**Planning Department  
Transportation Development Services**

December 17, 2015

**Re: O'Reilly Auto Parts (A15)**  
**12700 Lomas Blvd., NE**  
**Traffic Circulation Layout**  
Engineer's/Architect's Stamp dated 12-14-15 (K22-D019)

3 SIGHT DISTANCE EXHIBIT A

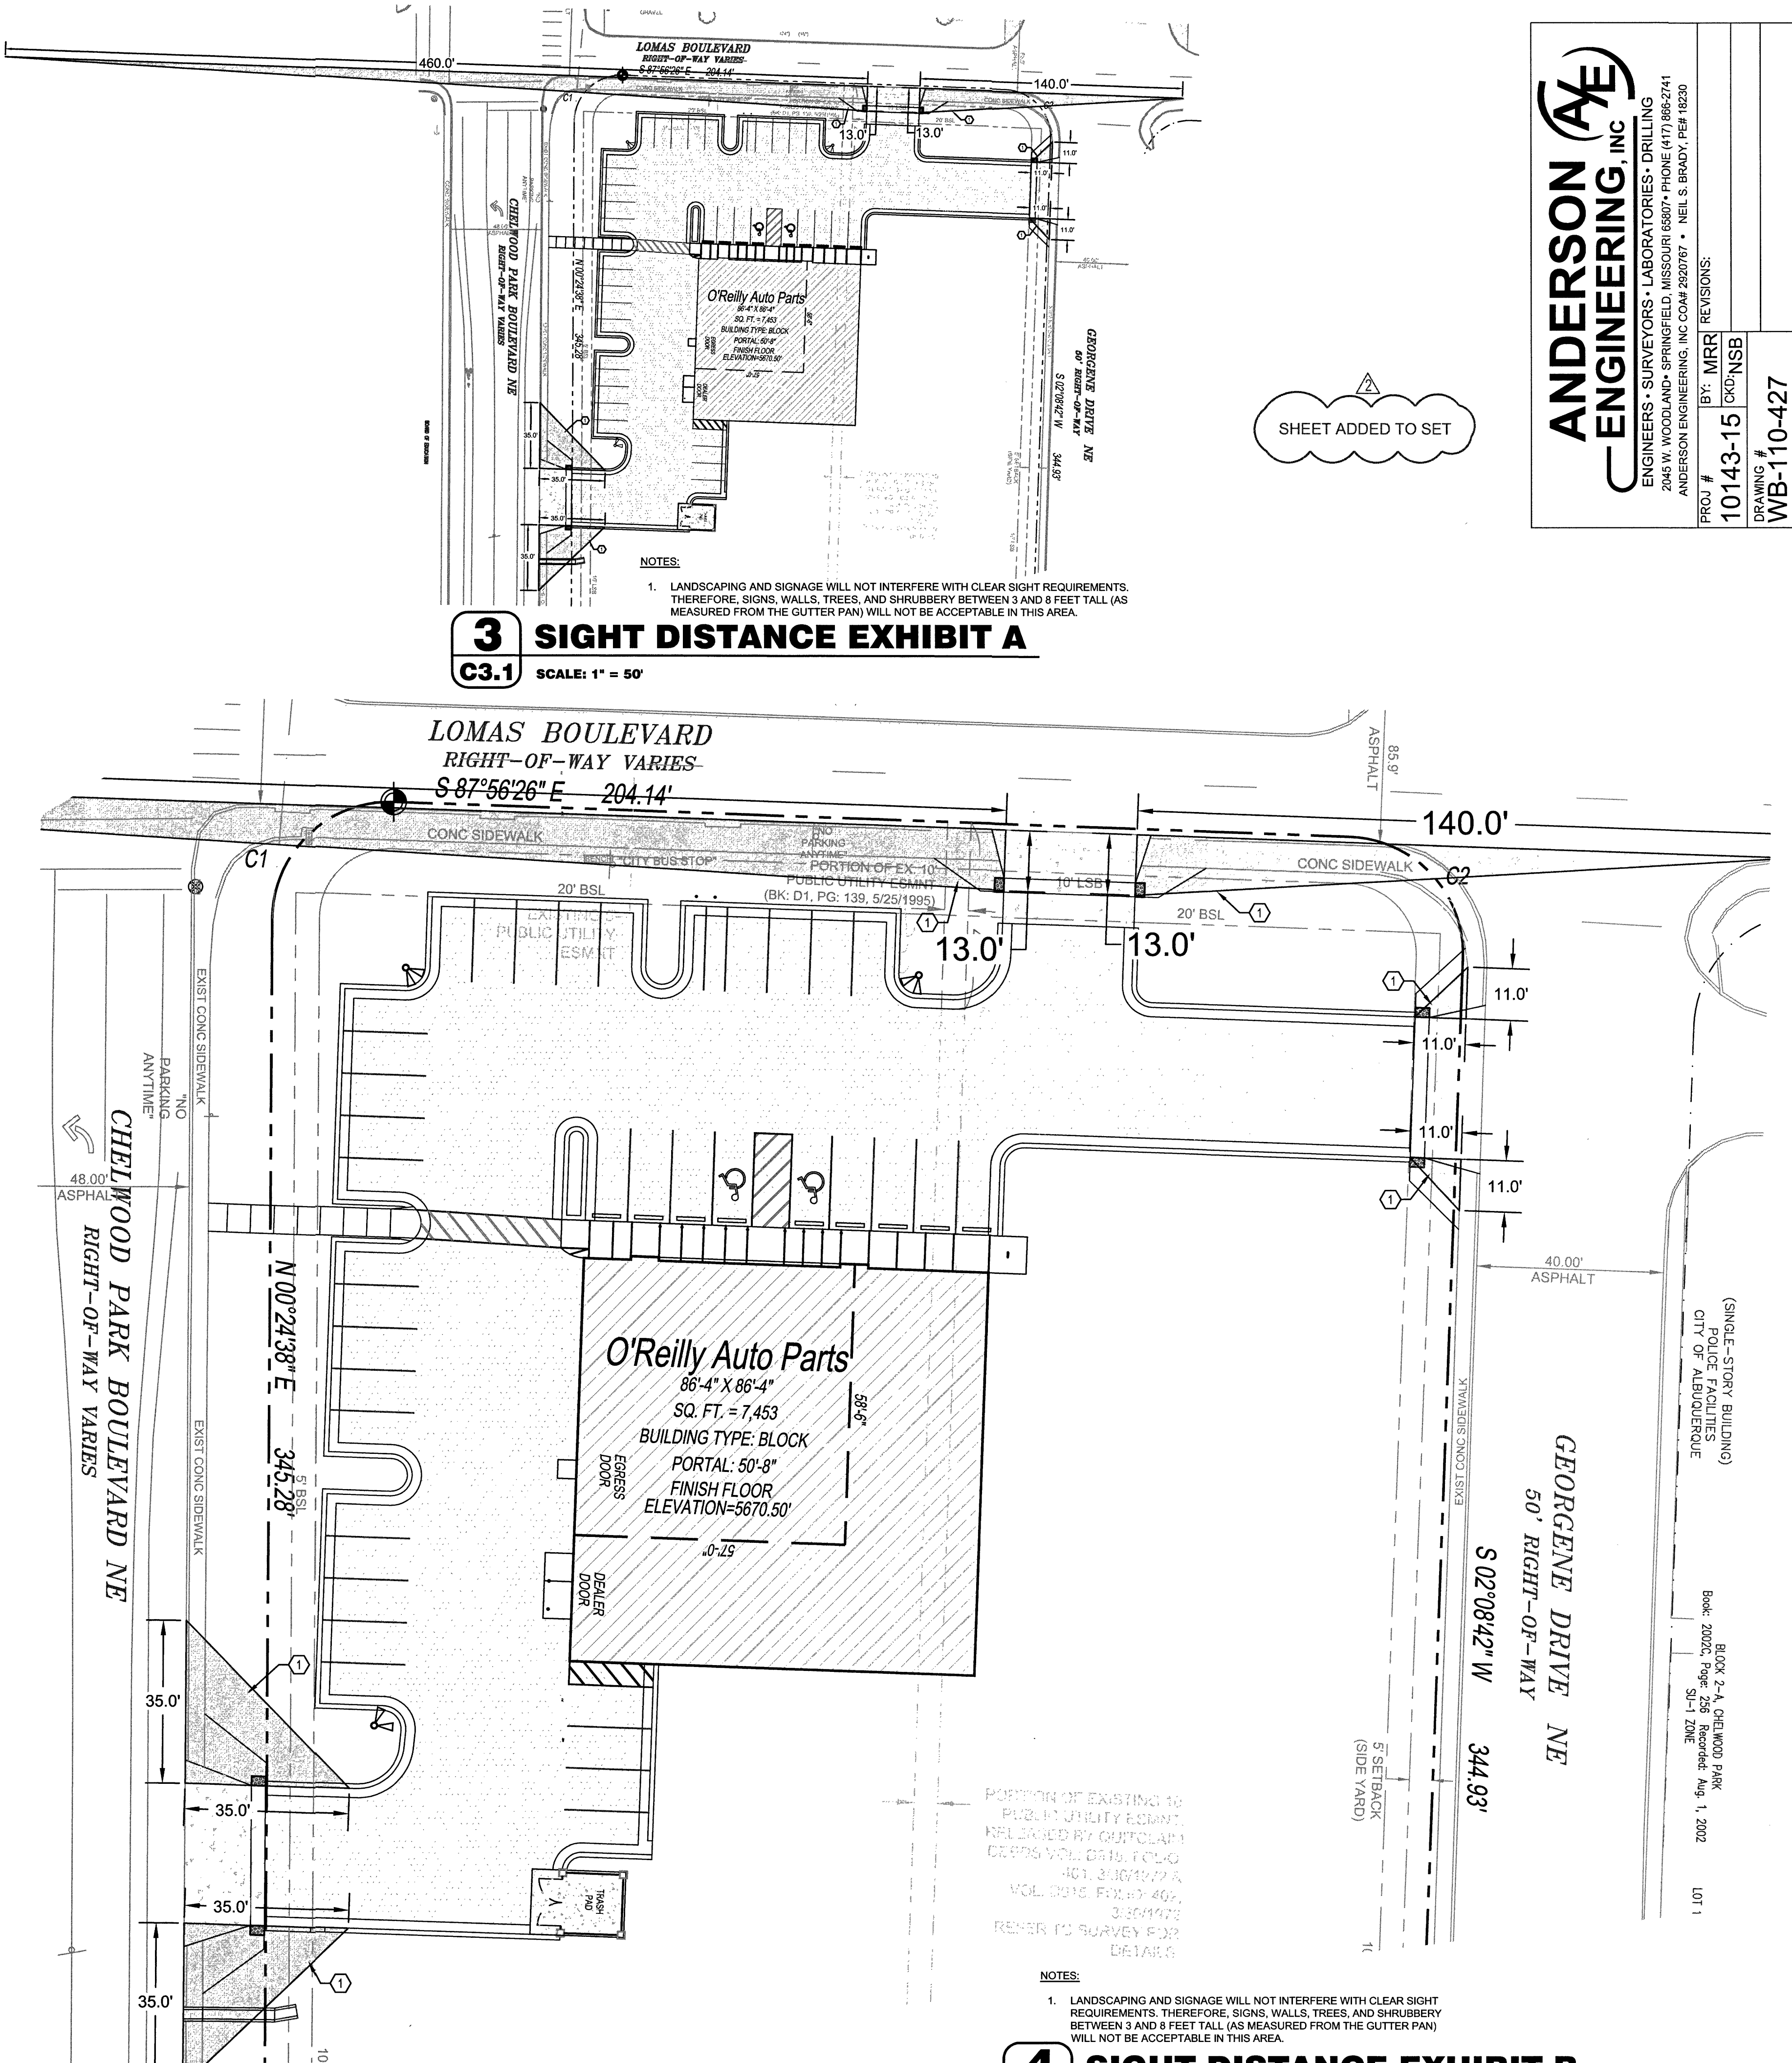
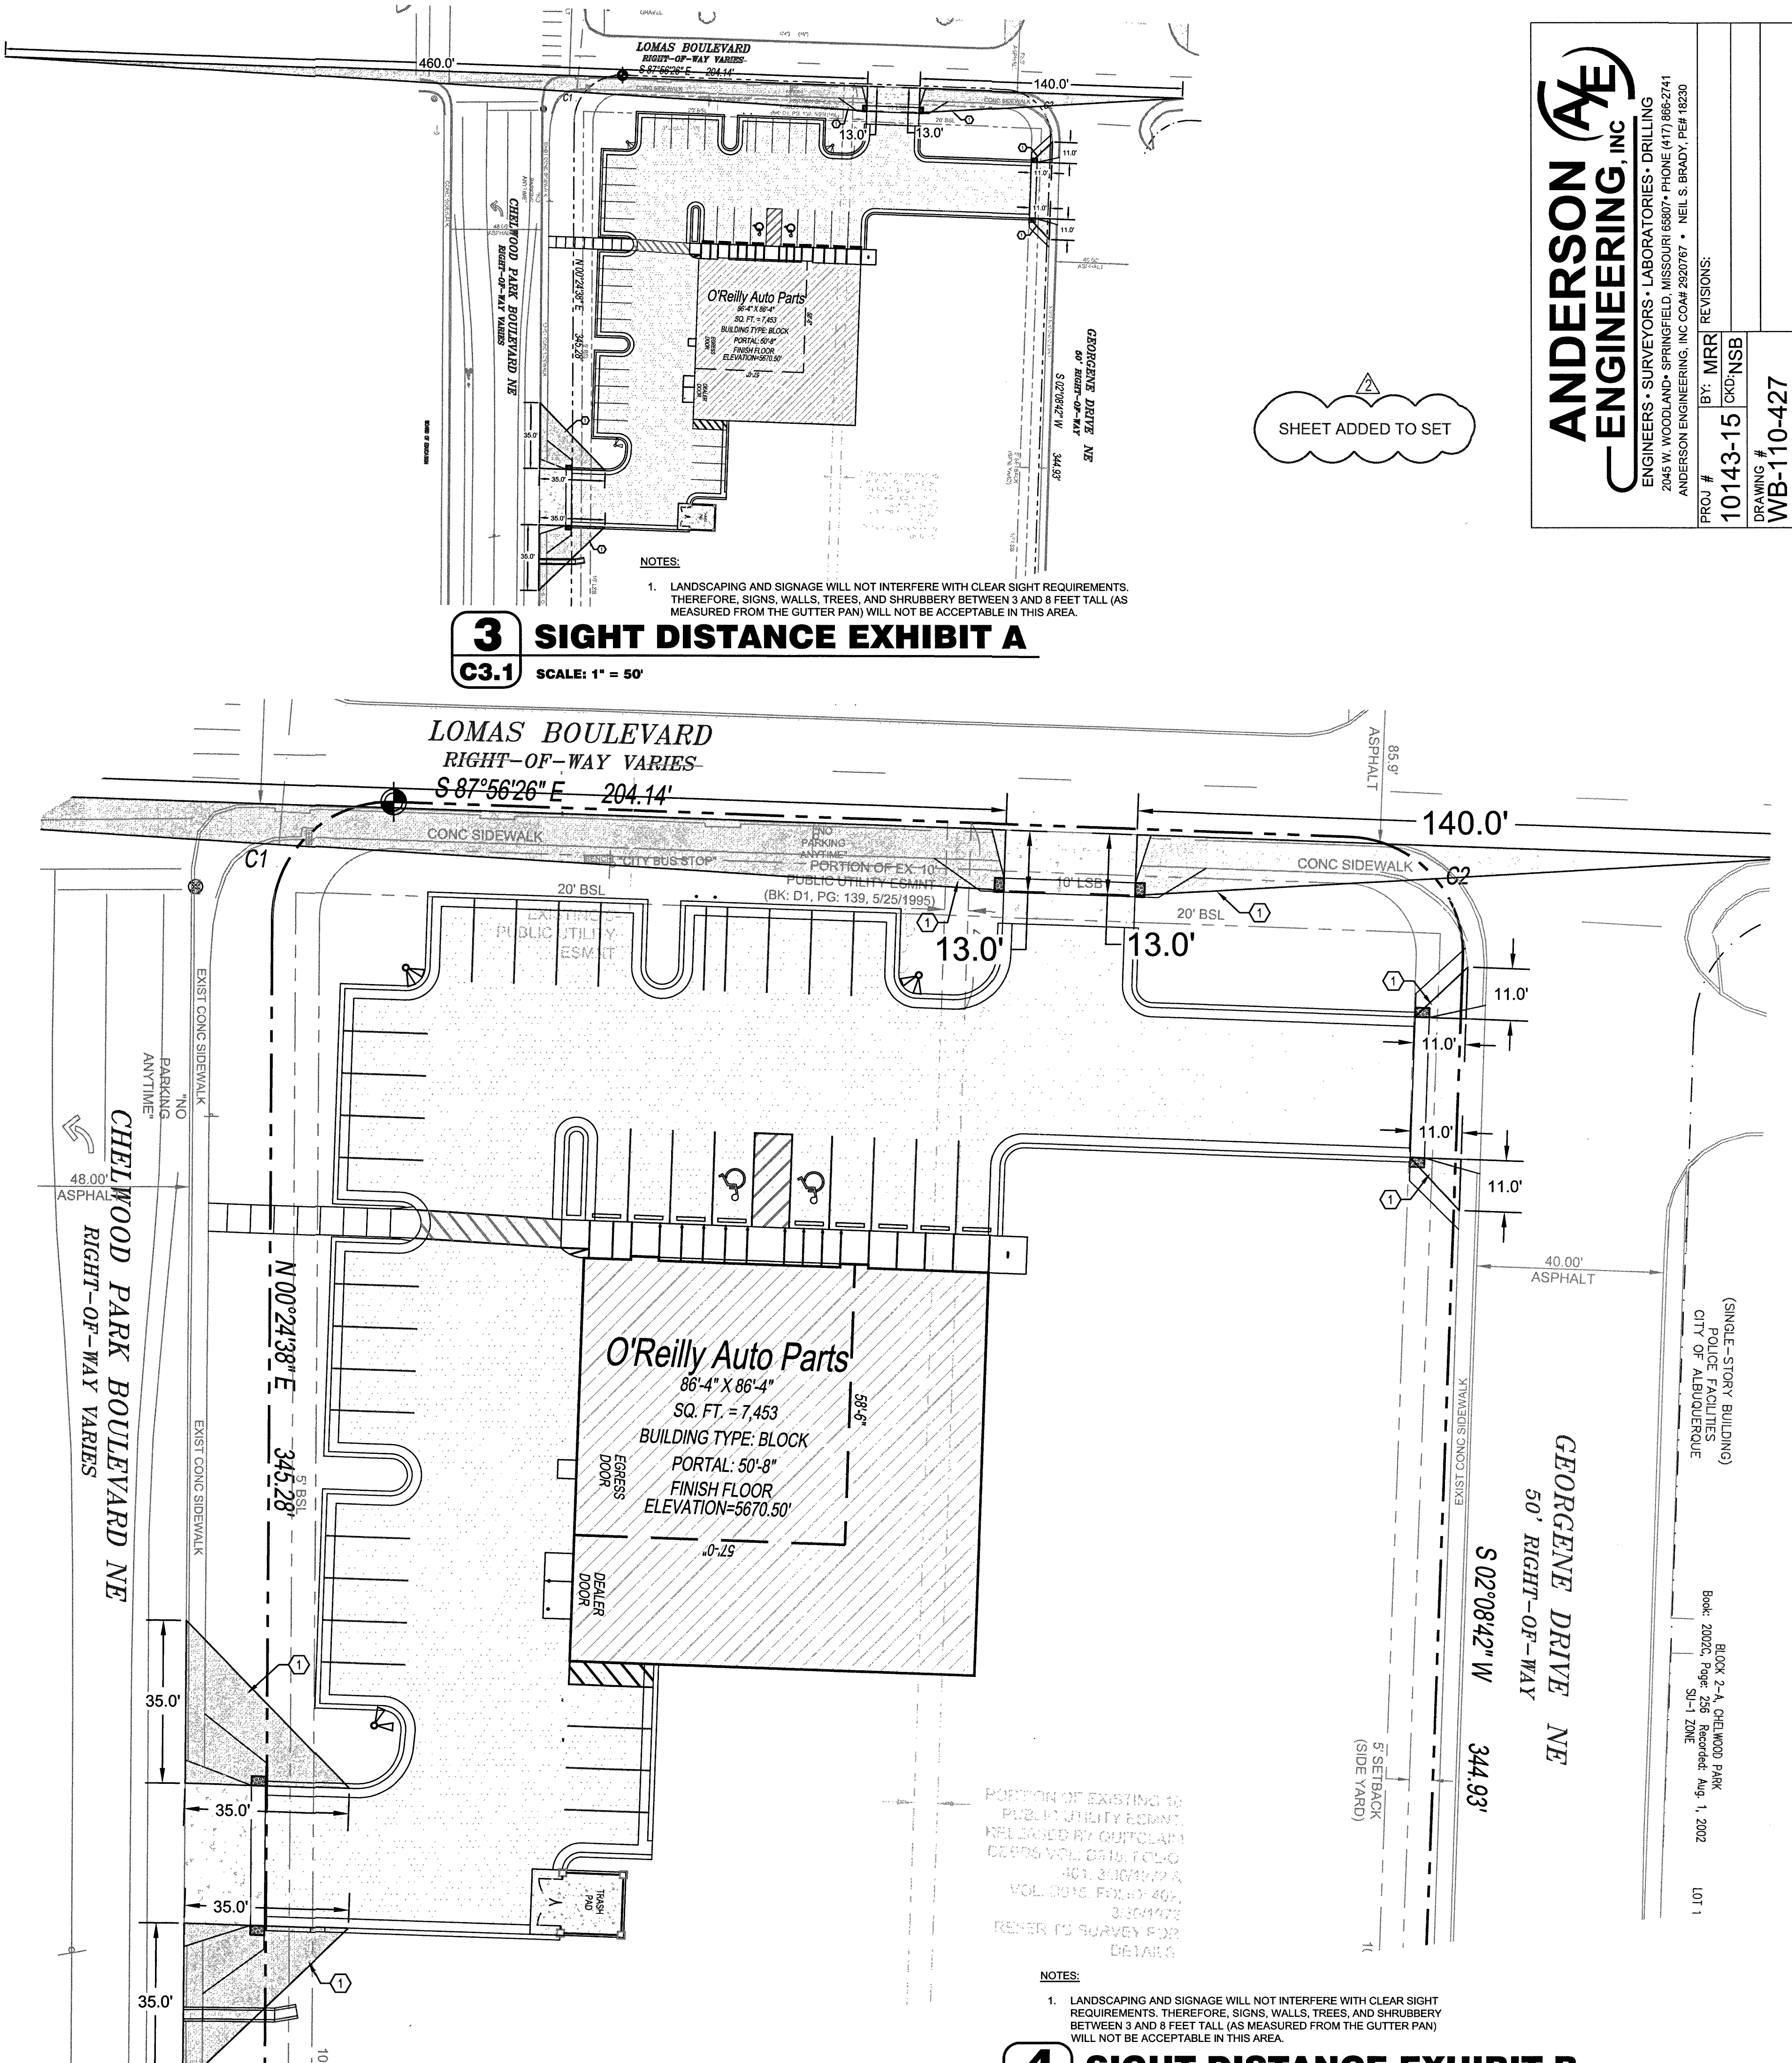
1. The handicap accessible spaces must be a minimum of 8.5 feet in width.
2. Please provide a sight distance exhibit (see the *Development Process Manual, Chapter 23, Section 3, Part D.5 Intersection Sight Distance*). Please show this detail for entrances/exits on Chelwood Park Ave., Lomas Blvd., and Georgene Dr.

3. Please add the following note to the clear sight triangle: "Landscaping and signage will not interfere with clear sight requirements. Therefore, signs, walls, trees, and shrubbery between 3 and 8 feet tall (as measured from the gutter pan) will not be acceptable in this area."
